From: Anita Gardner <Anita.Gardner@arun.gov.uk>
Sent: 02 November 2020 09:52
To: Planning.Responses <Planning.Responses@arun.gov.uk>
Subject: FW: M/72/20/DOC- Land West of Yapton Road (Poultry Farm)

Thank you for consulting us on this application to discharge conditions 11, 13 and 14. We have the following comments.

Comments on Condition 11- Surface Water Drainage Design

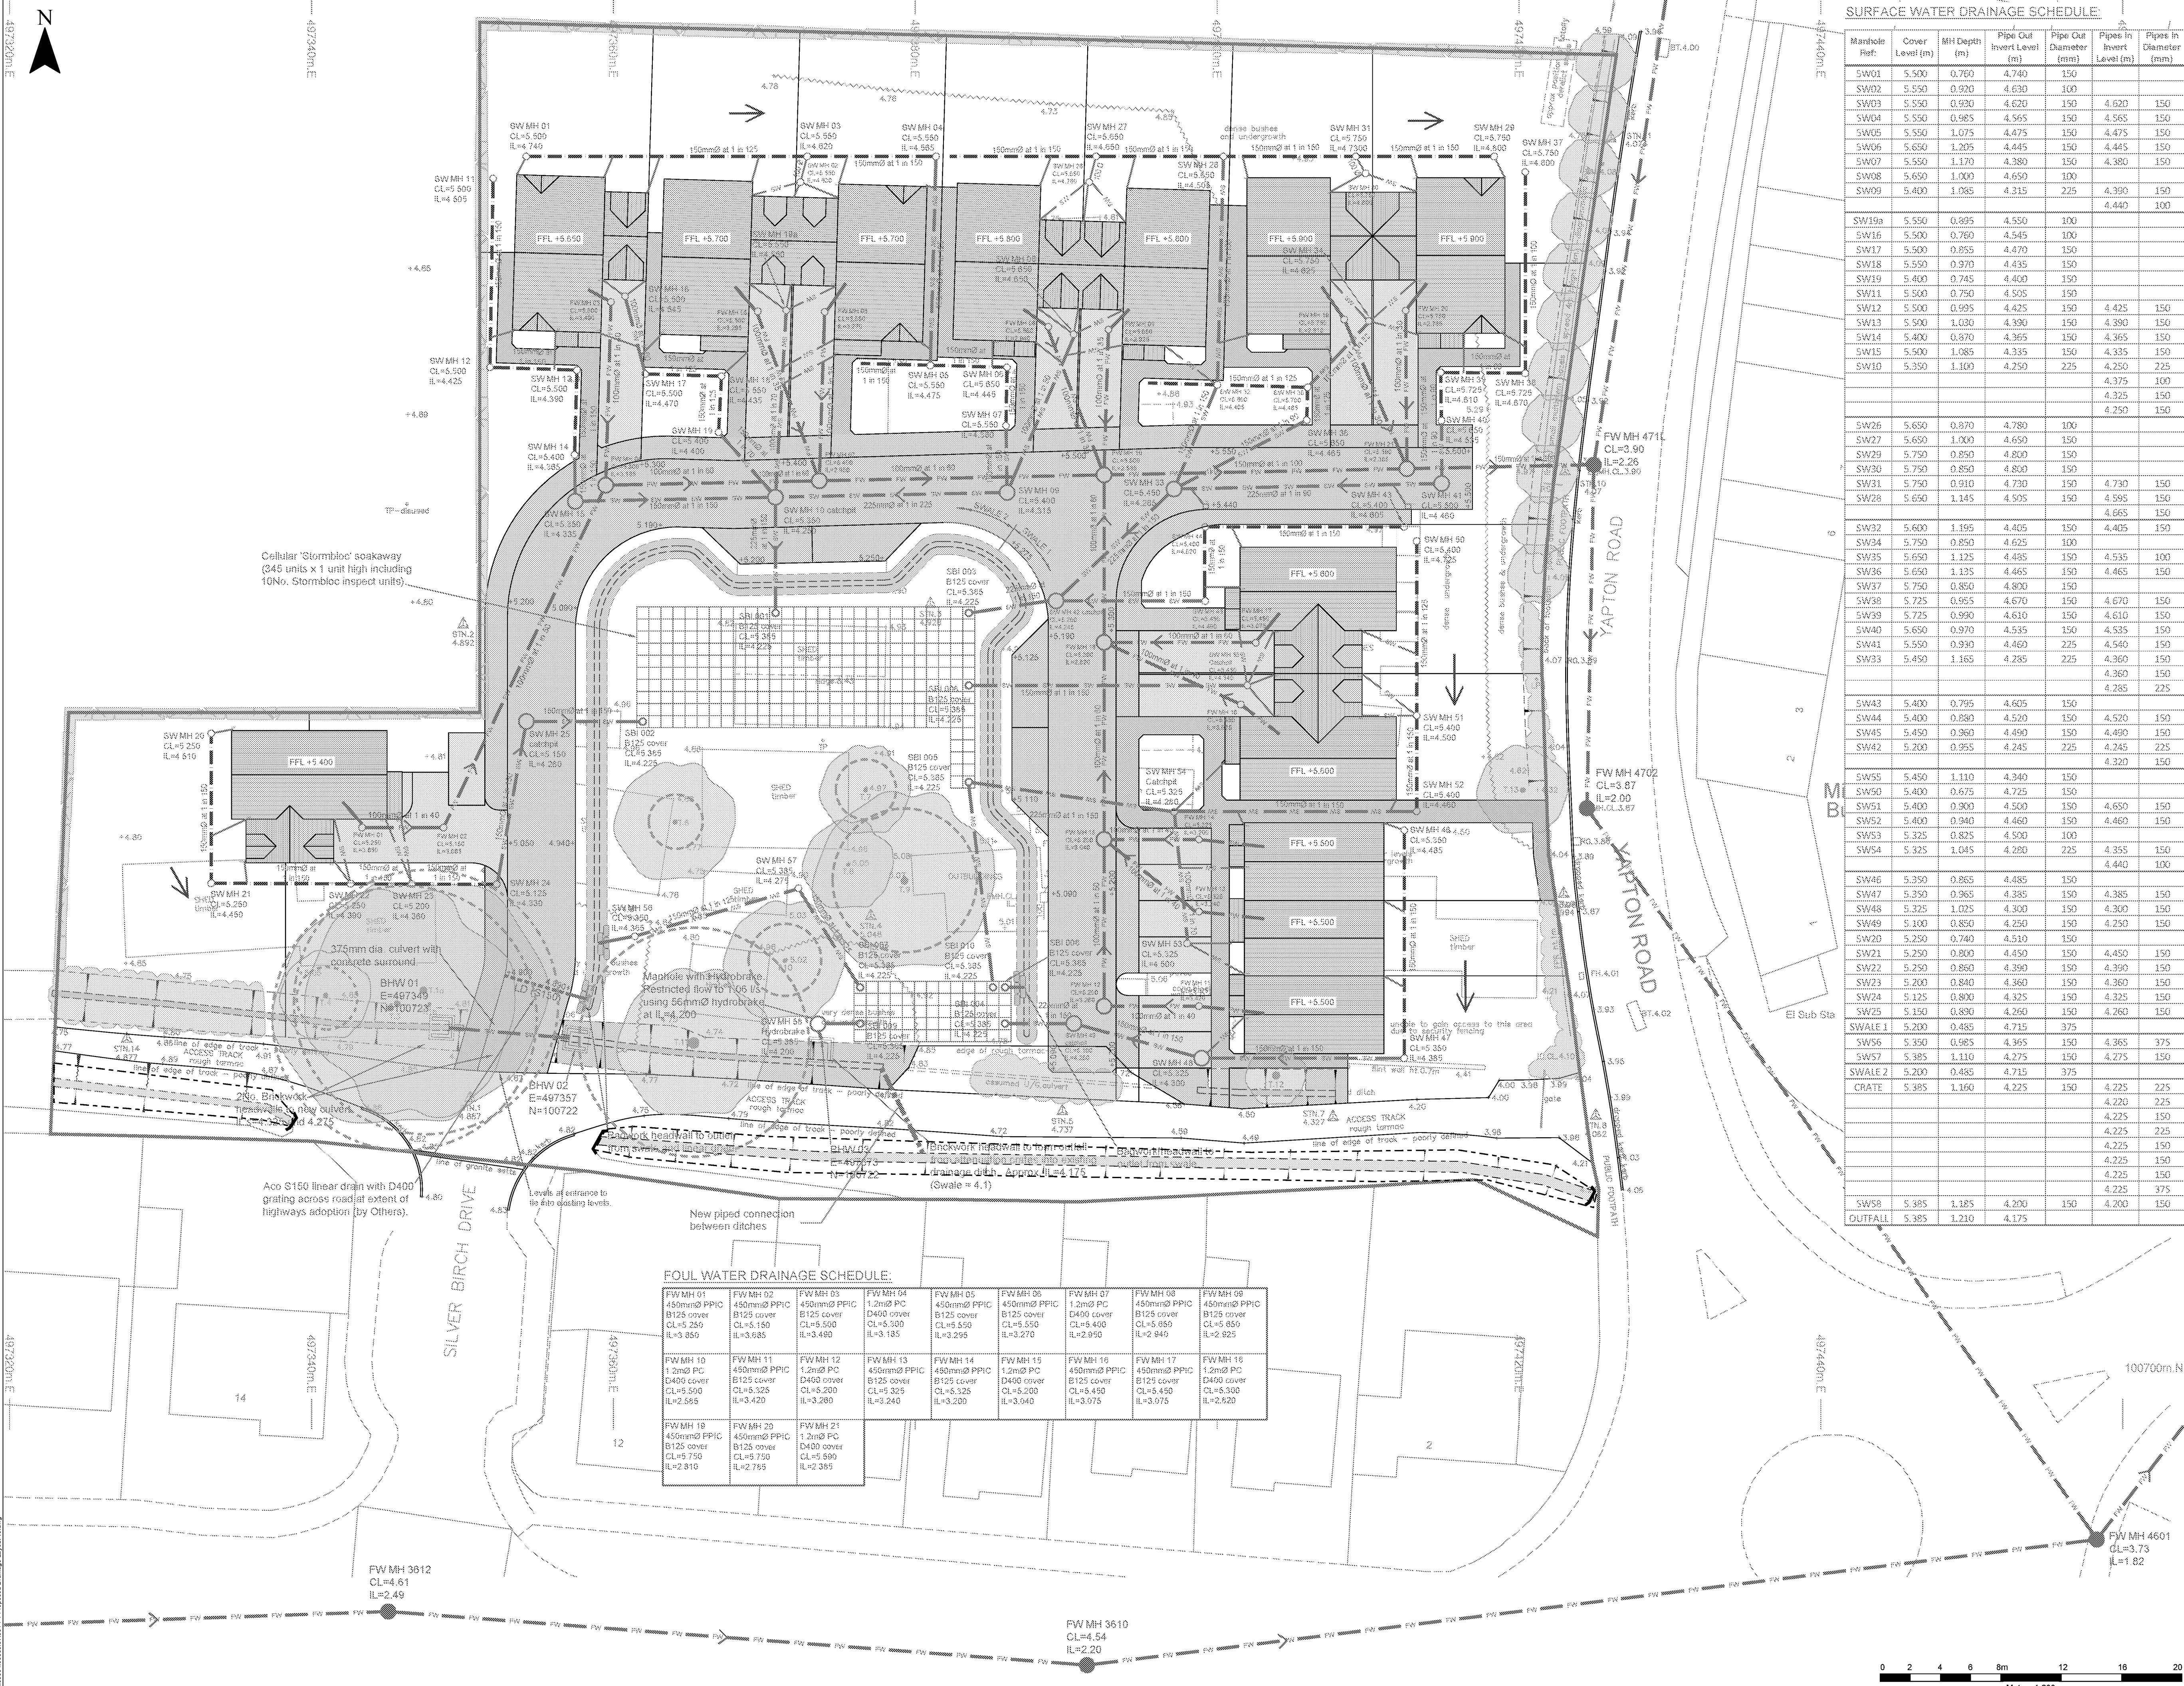
5. Please clearly mark invert levels of the proposed swale. Invert levels provided on proposed swale -- Please see Drawing 402.06594.00008.07.001 -- Proposed Drainage Layout.

6. Please confirm on plan where sumps and catchpits are proposed. Catch pits clearly marked on drainage layout.
7. Please provide a flow exceedance plan. Please see attached -- Drawing 402.06594.00008.07.005 -- Proposed Exceedance Route.
